Response to Submissions

State Significant Development Application (SSD 7500) Proposed Warehouse & Logistics Hub

5 & 9 Culverston Road, Minto (Lot 3 in DP817793 & Lot 400 in DP87511)

Figure 1: Approved Architectural Site Plan (drawing 116101_A-SSD_A0006, issue 9, by Reid Campbell, dated 29/02/2017)

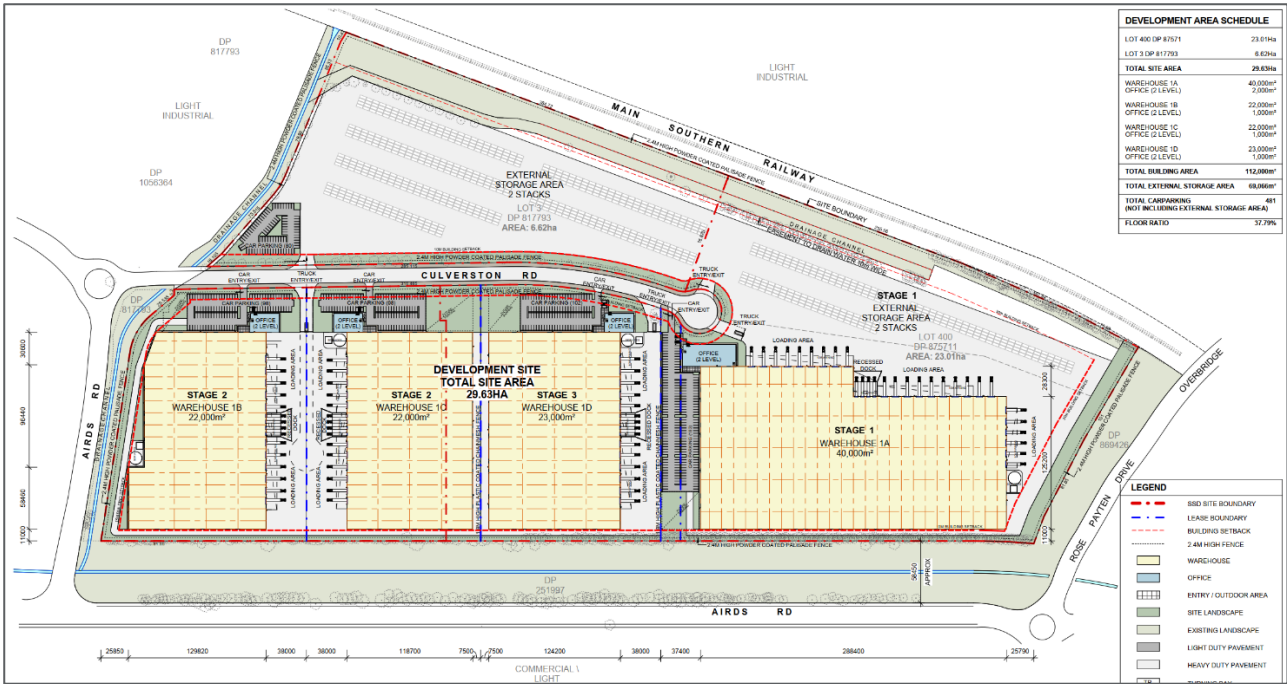
a) *The proposed outdoor storage areas will not be adequately screened from public places (Culverston Road, Rose Payten Drive and the Main South Rail Line). This matter was raised with the applicant at the pre lodgment stage and it is evident that this matter, and the importance of this matter to the Council, has not been given the anticipated attention. Council strongly objects to any outdoor storage area that is not adequately screened. The relevant clauses of Part 7 of the Campbelltown Sustainable City DCP 2015 are listed below:*

- ii. *Outdoor storage areas shall be adequately screened from public view.*
- iii. *Goods and materials stored shall not be stacked higher than an approved screening structure.*
- iv. *Screen fencing and structures shall be constructed of high quality materials that complement the buildings located on site.*
- v. *All outdoor storage areas shall be sealed and drained to the storm water system in accordance with any environmental management requirements.*

All screening structures shall be located behind the required landscaped areas. Specifically, landscaping fronting the Main South Rail Line and Rose Payten Drive shall be of significant height so as to obscure views of the site.

Comment: As shown on drawing 116101_A_SSD_10013 & 116101_A_SSD_A006, a setback in excess of 30m from the storage containers to the property boundary of the subject site adjoining the Southern Railway is provided. This area will consist of dense landscaped buffers and a 2.4m high powder coated fence. That screen screens the container stacks that will be a maximum of two containers high.

Comment: As previously stated, container stacks are proposed to be a maximum of two containers high. This will be less than the 13.7m height of the proposed warehouse facilities, and in conjunction with the separation to the boundary, dense landscaping and powder coated fencing (2.4m high), the outdoor storage area shall not be visually dominant when viewed within the public domain or from surrounding properties.

## NORTHERN BOUNDARY LANDSCAPE SECTION

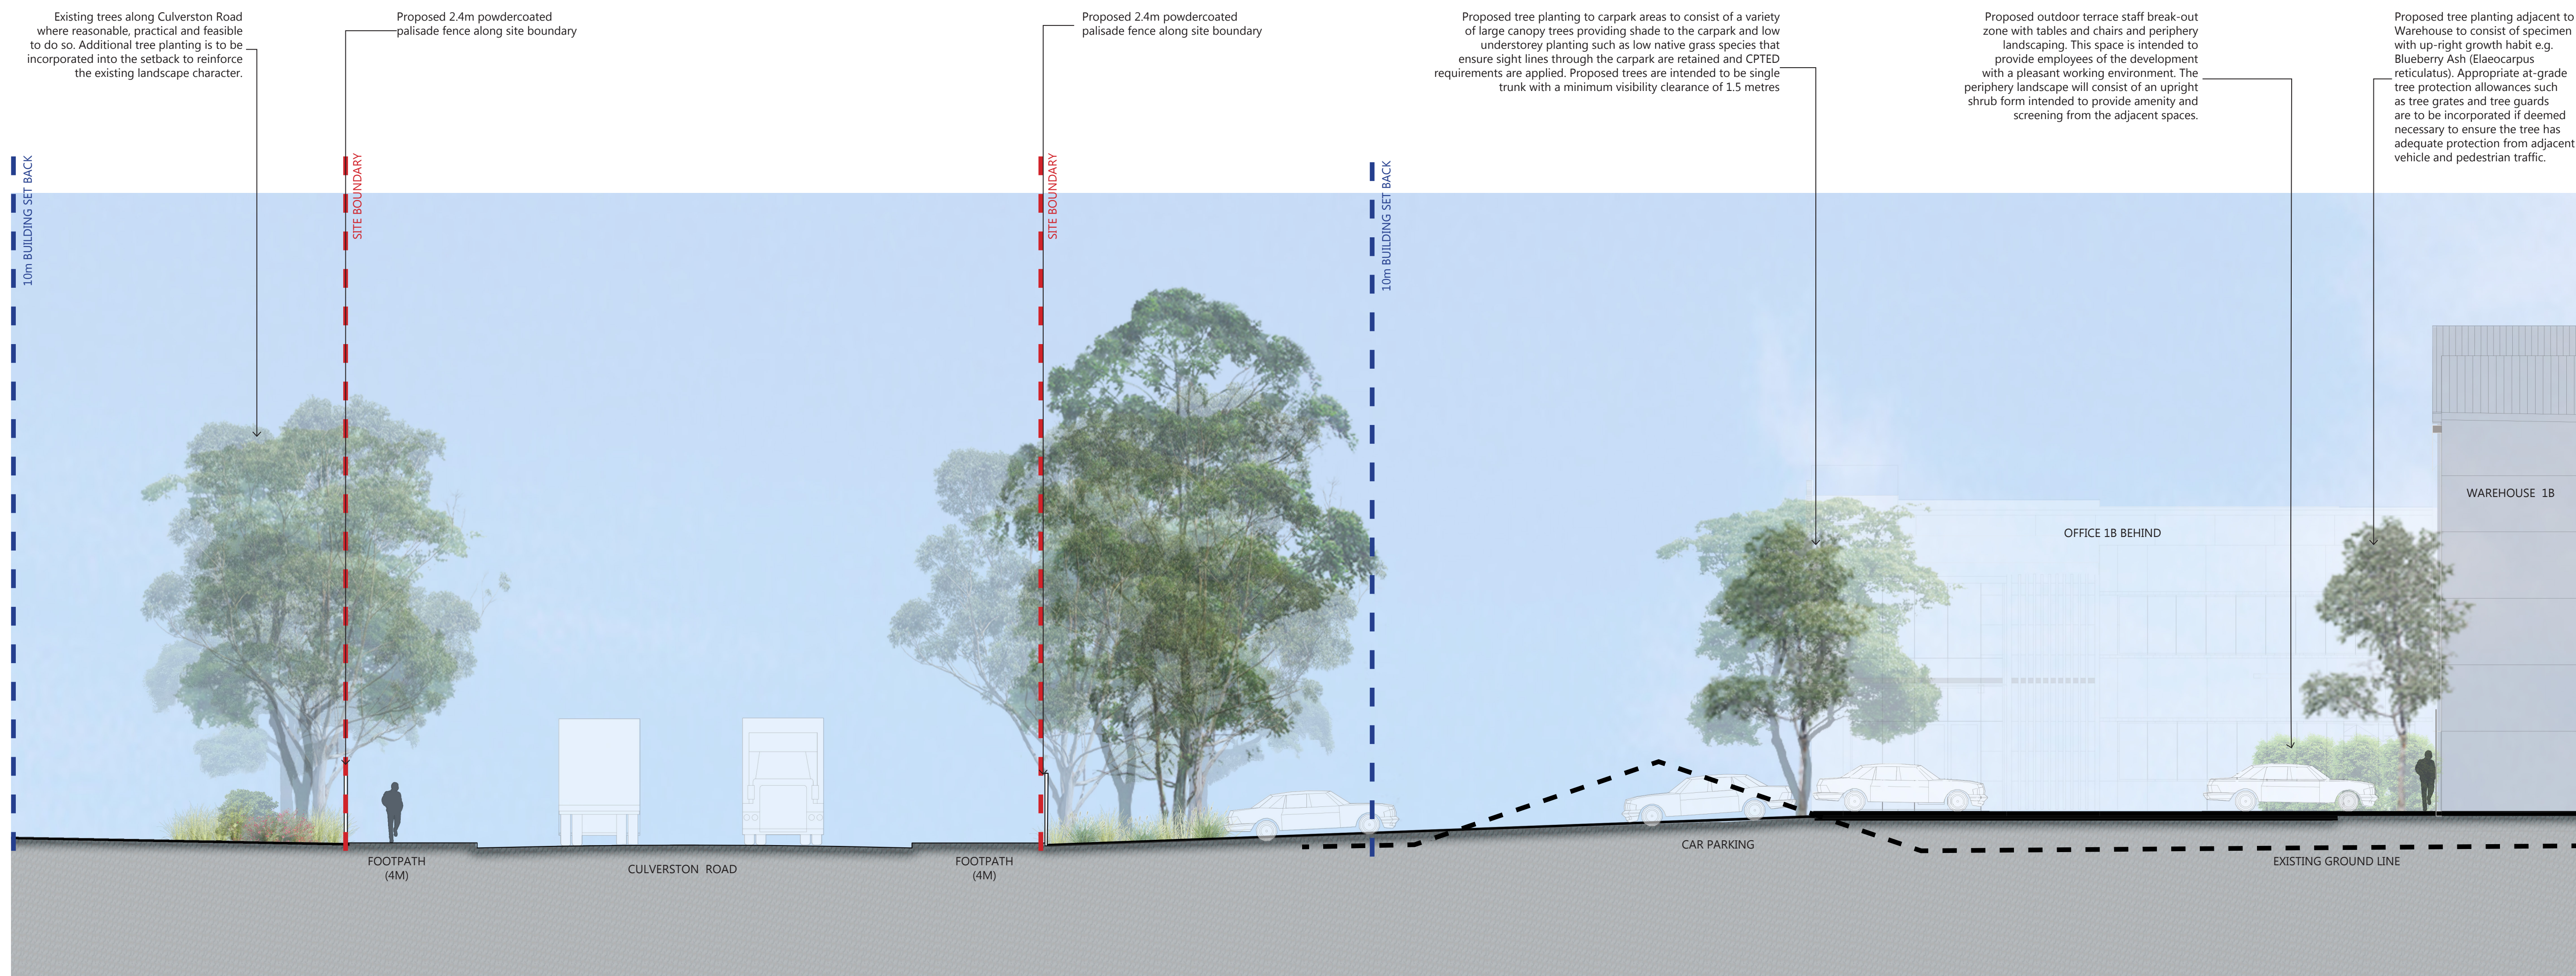
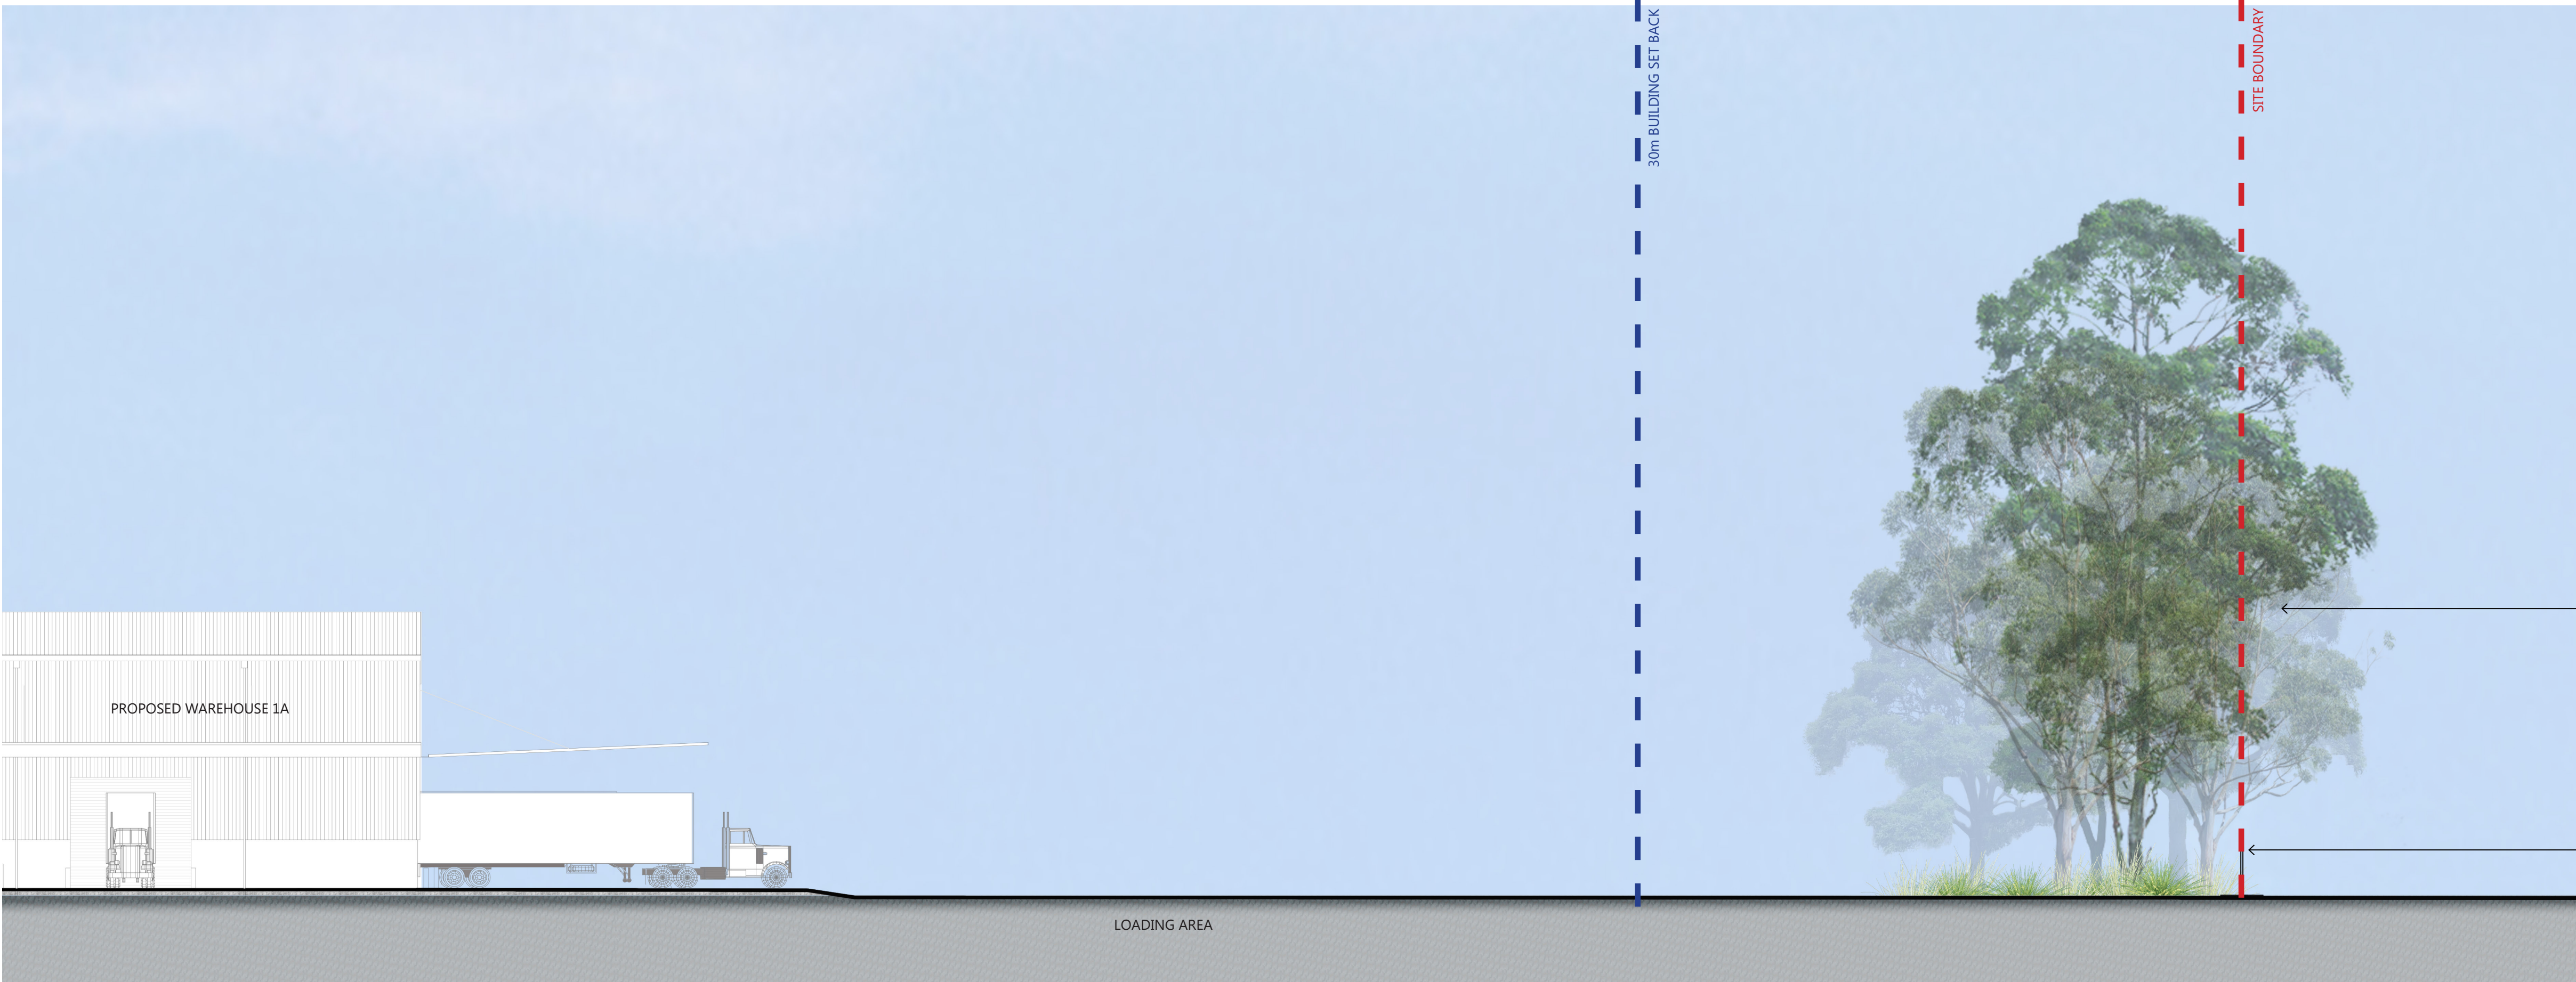
<p>b) <i>The front fencing to the development fails to comply with Part 7 of the Campbelltown Sustainable City DCP 2015:</i></p> <p><i>"All fencing in industrial developments shall be setback a minimum of 3.0 metres from property boundaries addressing a primary and/or secondary street."</i></p> <p><i>Council requests that the front fencing to the development be setback 3 metres and the area between the fencing and the property boundary landscaped, in accordance with Council's policy.</i></p>	<p>As shown on drawing 116101_A_SSD_A006, the proposed palisade fencing is to be setback 3m from the property boundary, thus enabling landscaping to be provided that can sufficiently screen the subject site. At maturity, the landscaping proposed, in conjunction with the substantive building setbacks, will provide a buffer that results in the scale and overall development area being portrayed as unobtrusive and commensurate with the industrial character of the locality.</p>

<p>d) <i>Compliance with some of Council's landscaping standards could not be determined, as the landscape plan supplied lacks detail. Council requests a full landscape plan showing species, heights and pot sizes of all plants and trees. It is requested that compliance with the following landscaping standard be ensured:</i></p> <p><i>"The first three (3) metres of all required street front landscaped area (as measured from the street boundary) shall be planted of advanced canopy trees that are:</i></p> <p><i>i) a minimum of two (2) metres in height with a minimum 400 litre pot size at the time of planting;</i></p> <p><i>ii) of native species; and</i></p> <p><i>iii) planted /placed every 10 metres.</i></p>	<p>A revised Landscape Plan has been prepared by Ground Ink which provides planting details and species types that illustrates landscaping will serve as a sufficient visual buffer in and around the site (refer drawing No.1 LDA-001 dated 5.10.2016 prepared by Groundink).</p> <p>Typical plant schedules have been provided as follows:</p> <ul style="list-style-type: none"> ▪ Entrance and Culverston Road ▪ Northern buffer ▪ Western buffer ▪ Southern buffer <p>Sections have also been produced to provide a representation of the critical points of the site, and the height of the proposed plant species at maturity.</p> <p>It is considered that the proposed planting scheme provides a density of planting above and beyond that anticipated in the DCP and should therefore be supported by Council.</p> <p>The applicant requests flexibility with respect to landscaping along Culverston Road in the event it is closed and becomes a private road. Should closure proceed, FIt is nominated to provide a reduced width of landscaping along this frontage given the limited potential for it to be accessed and restricted use to the public.</p>

Comment: Powder coated palisade fencing (2.4m high) is proposed around the perimeter of the site, to ensure security and provide a clear delineation between public and private land. This fencing is considered to complement the industrial character of the site and intended land use, whilst setting a desirable precedent for future development within the locality.
